Meeting 28/3/08

Discussions initiated on drawings. Amendment will be submitted followed by planning app. occupation limited to house by condition.

Proposed North elevation

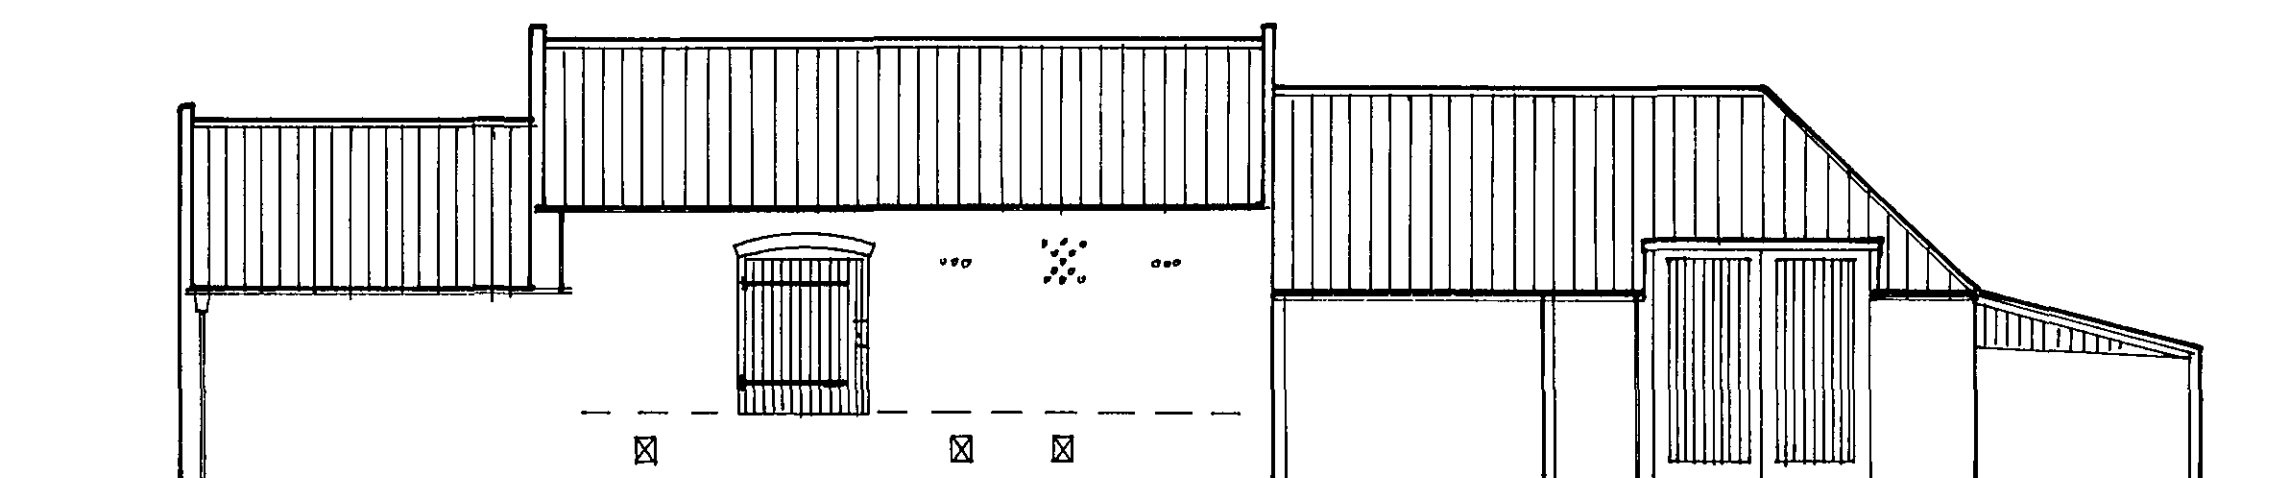
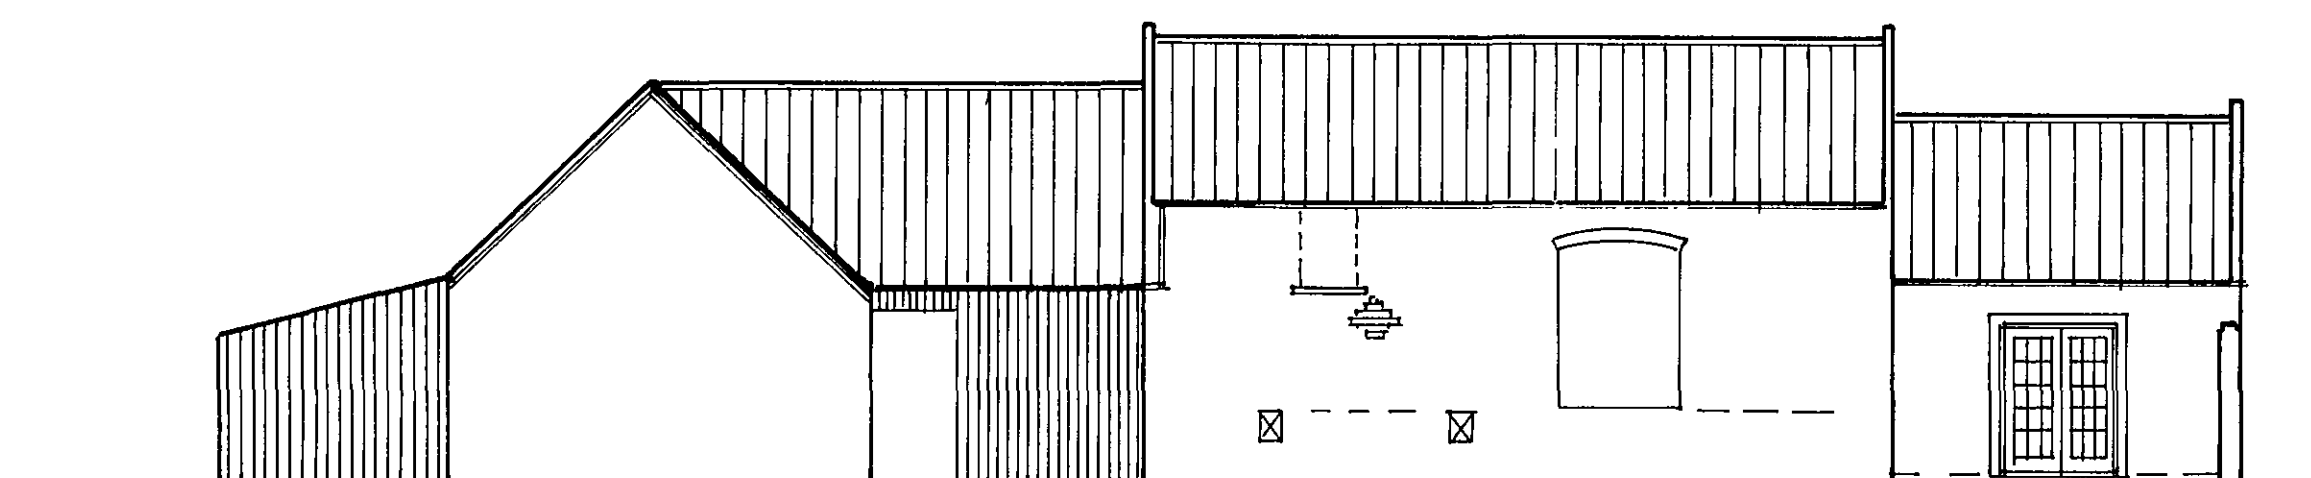
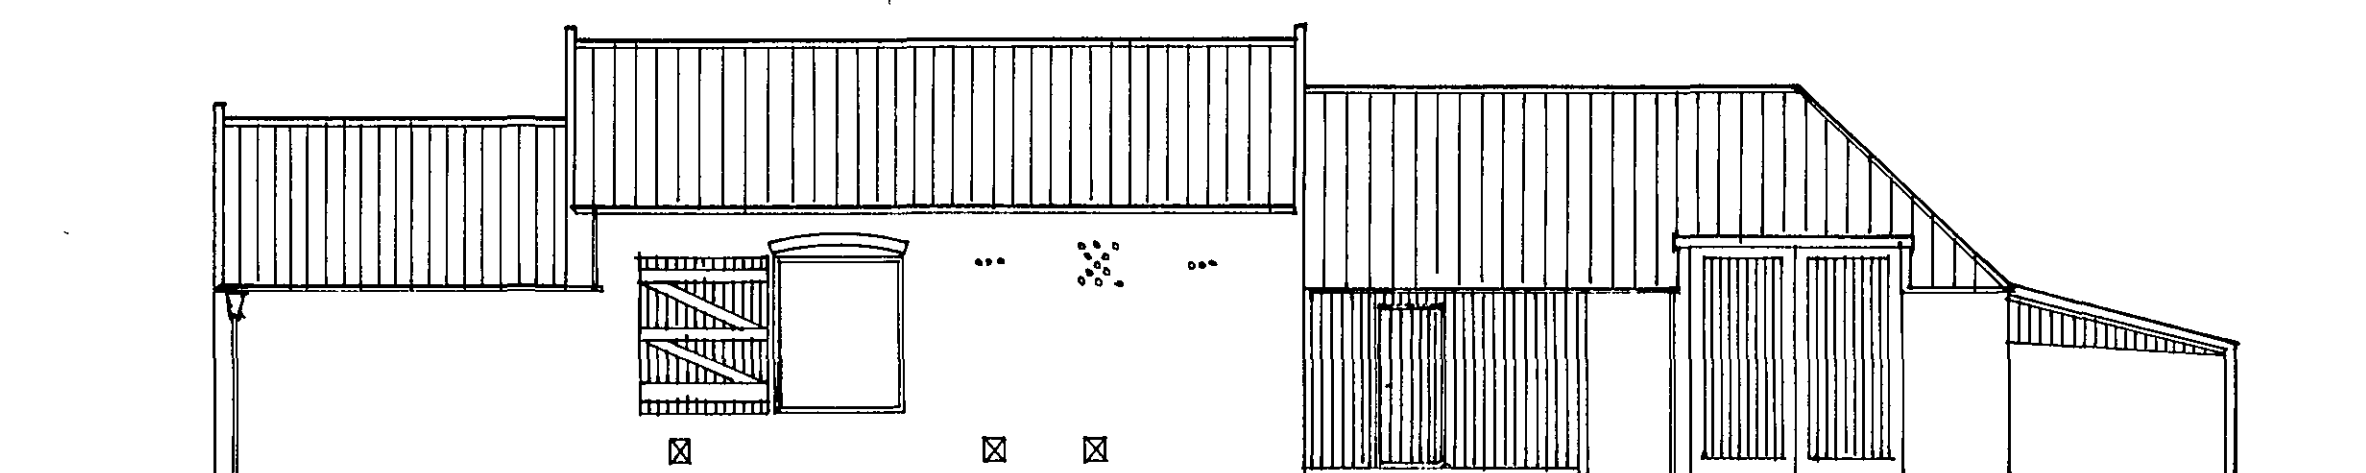
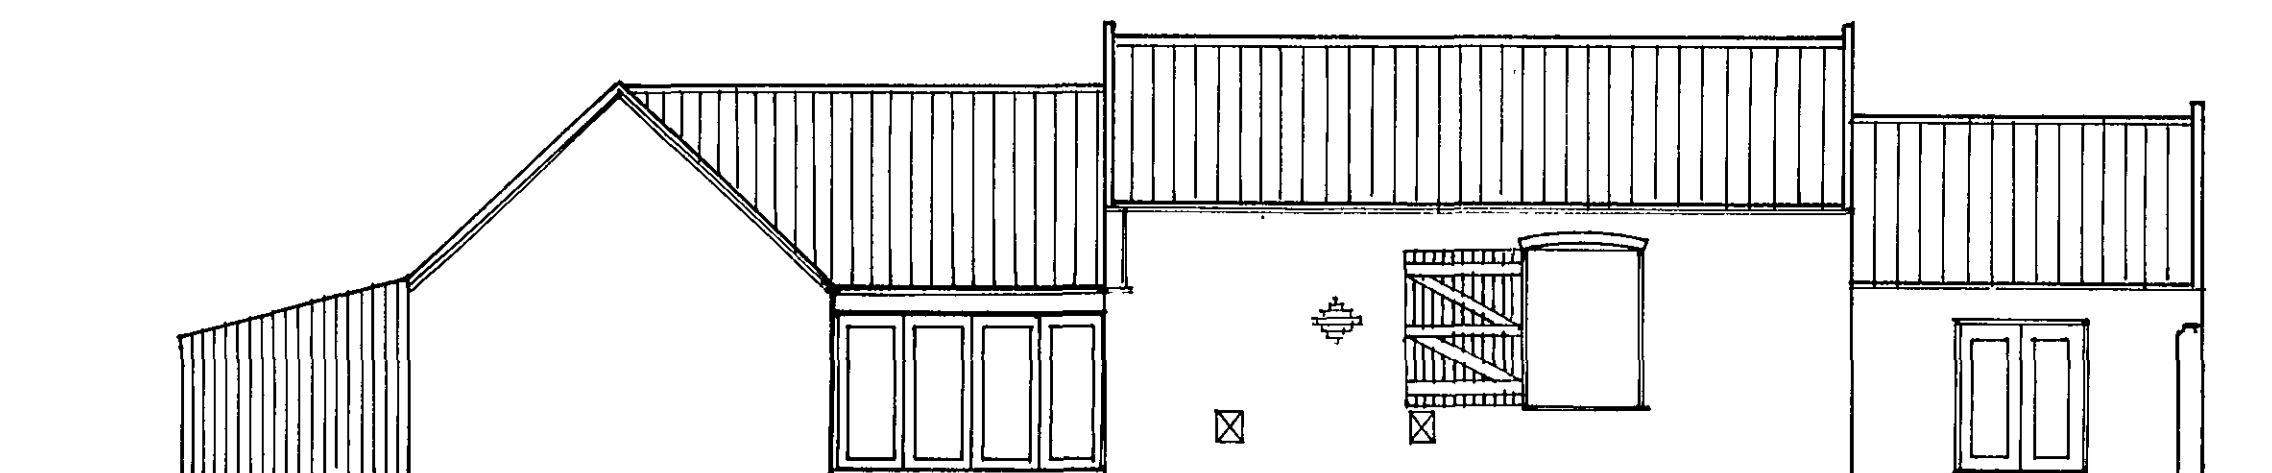
Why alter width of opening?

SITE PLAN 1:100

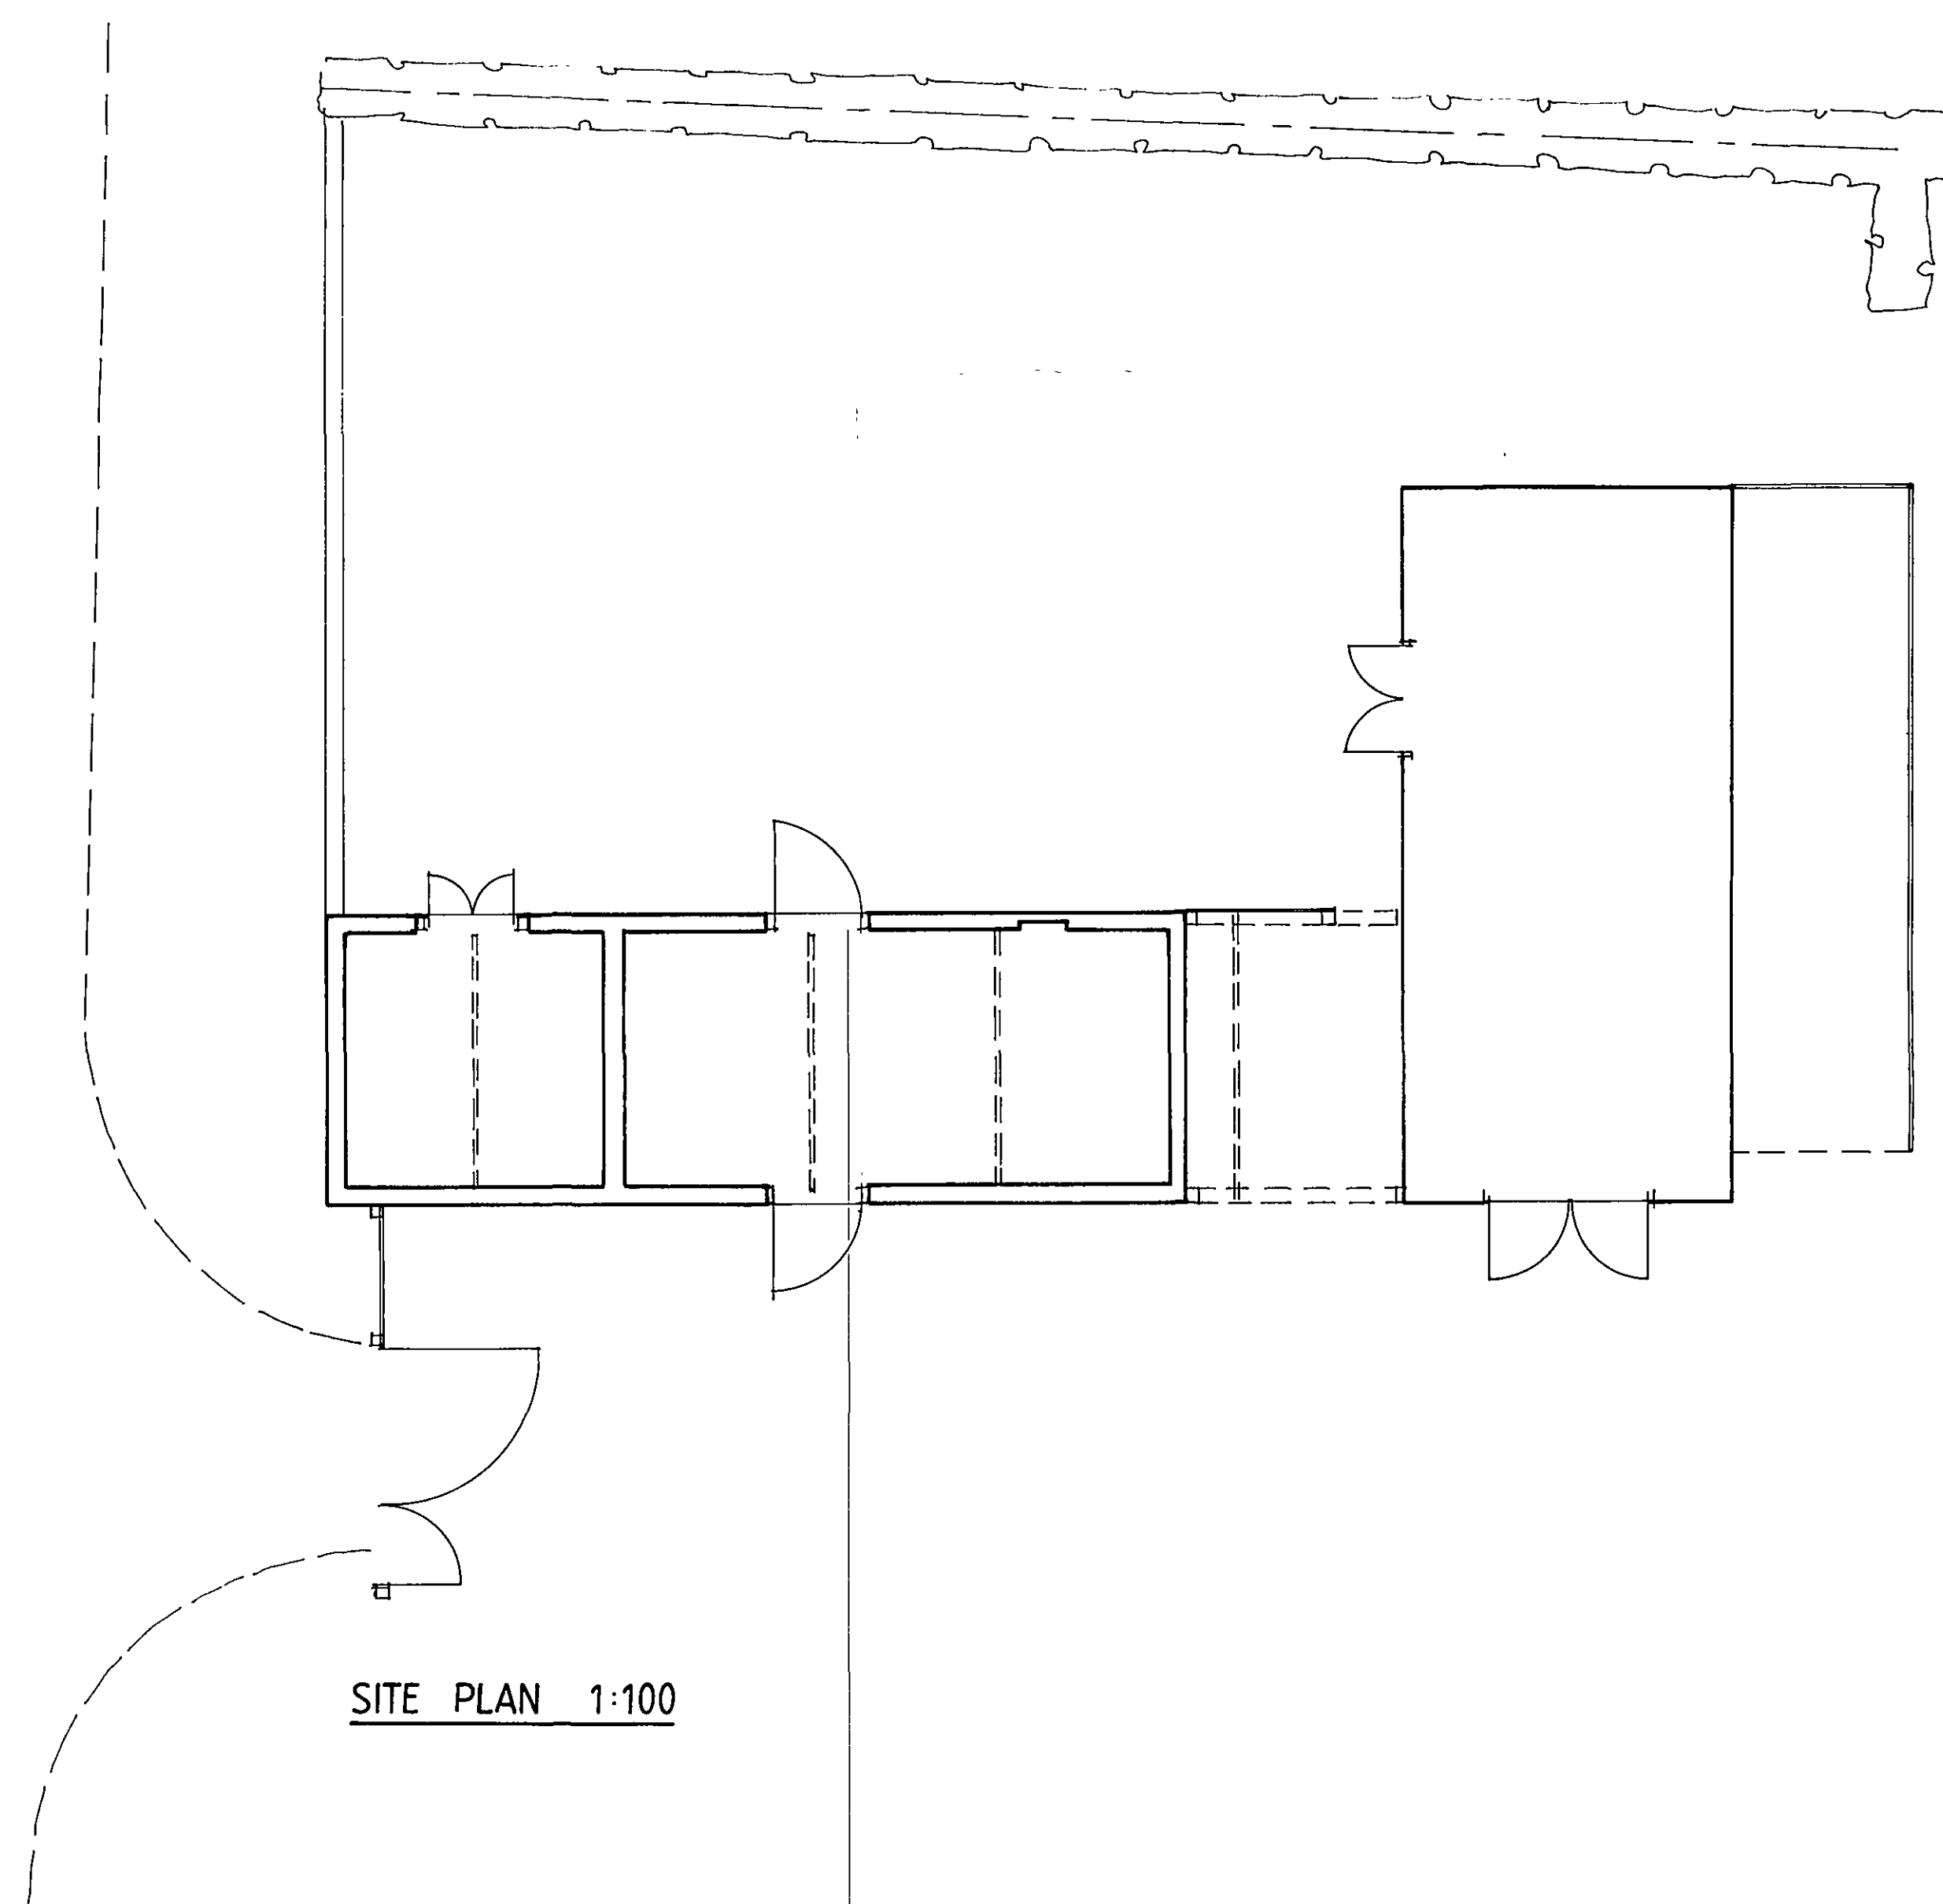
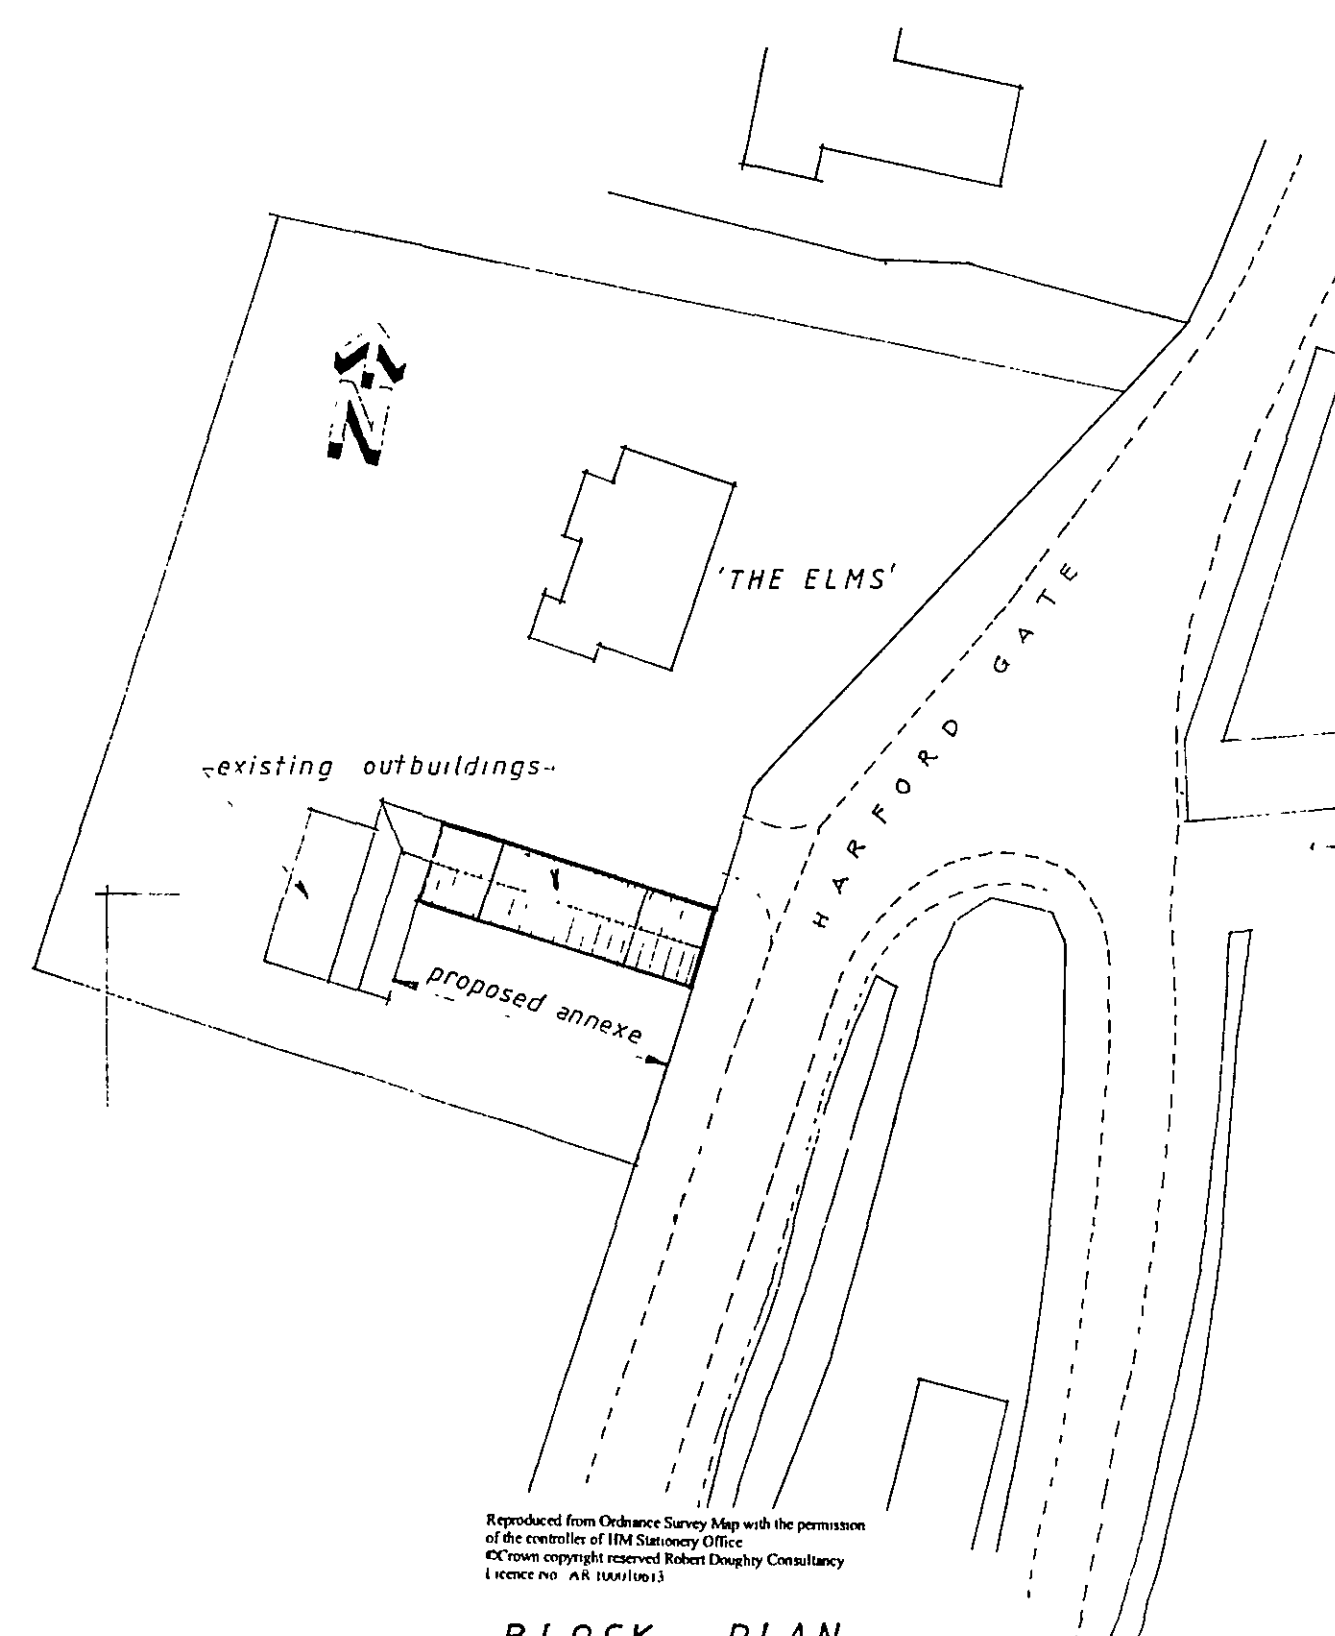
Why is new access needed? Annex only, could share driveway/parking with house.
